Arun District Council
Arun Civic Centre
Maltravers Road
Littlehampton
West Sussex BN17 5LF
Planning & Building Control General Enquiries
Tel: (01903) 737756 Fax: (01903) 730442
Dx: 57406 Littlehampton
Minicom: 01903 732765
e-mail: planning@arun.gov.uk
website: www.arun.gov.uk/planning

Application No: A/193/20/PL
Site Address: Ham Manor Cottage Ham Manor Way Angmering BN16 4JQ
Description of works: Erection of a 1 No. 3 bedroom chalet bungalow & detached garage. This site is in CiL Zone 3 and is CIL Liable as dwelling.

Thank you for your internet representation made on 14th February 2021 which has been recorded as an objection with the comments as follows:

Proposed Street Scene (Scale 1:200)

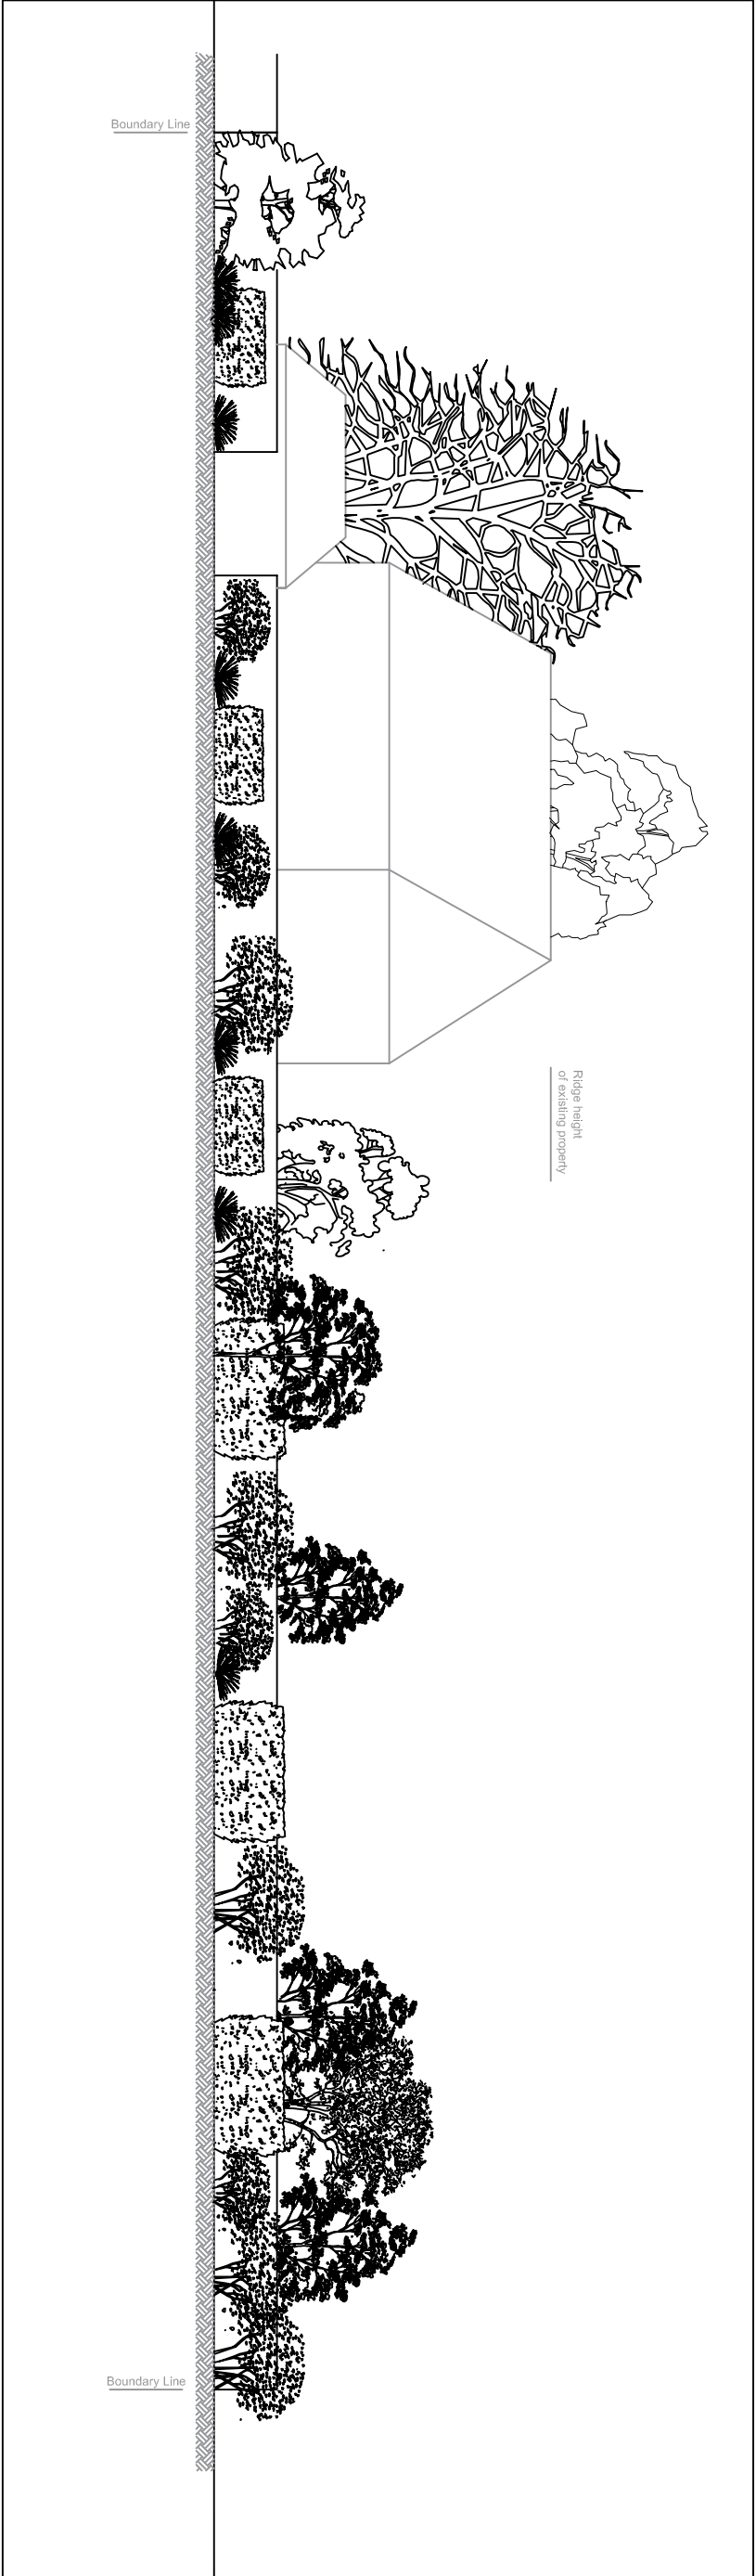
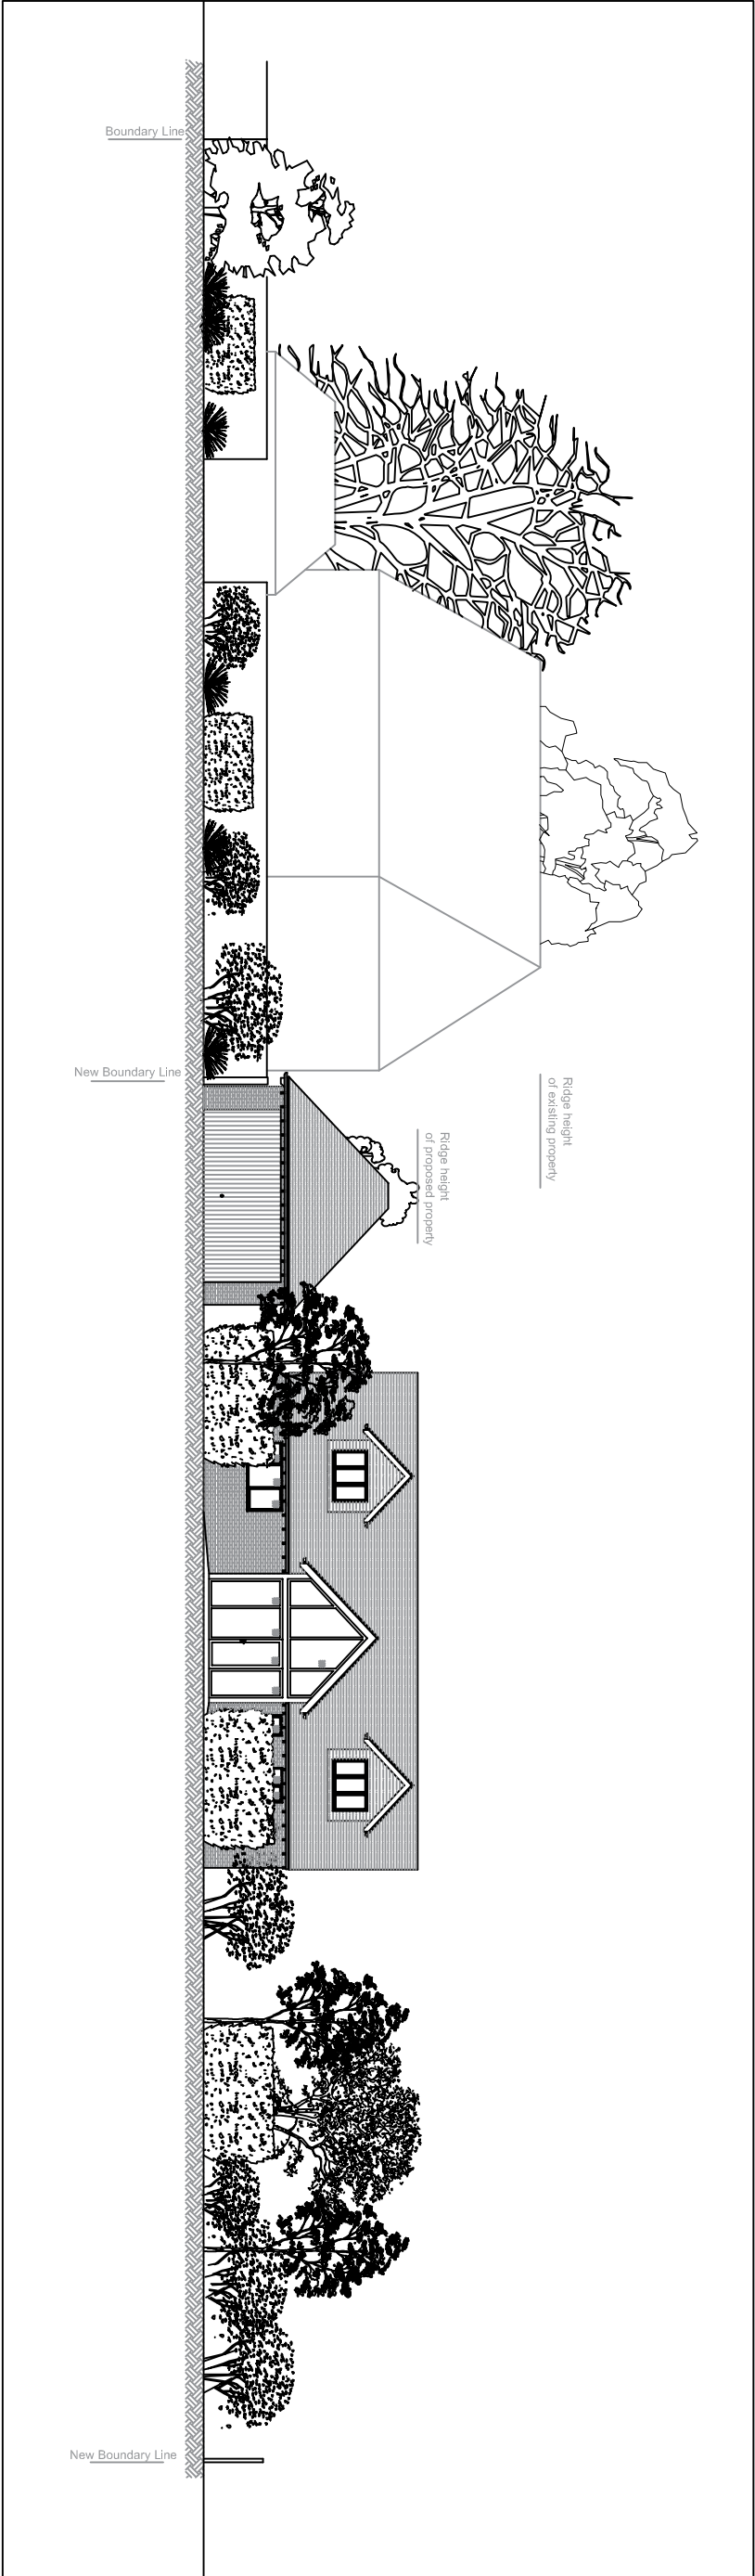
Specifically, we are concerned that the layout looks tight, with the two properties close together, so much so that the proposed building edges closer to the road. The beautiful thatched property already on the site sits very well at an angle to the road. In order to squeeze in the proposed addition, the building will be closer to the narrow Ham Manor Way and the properties opposite, making the area feel more 'built up'.
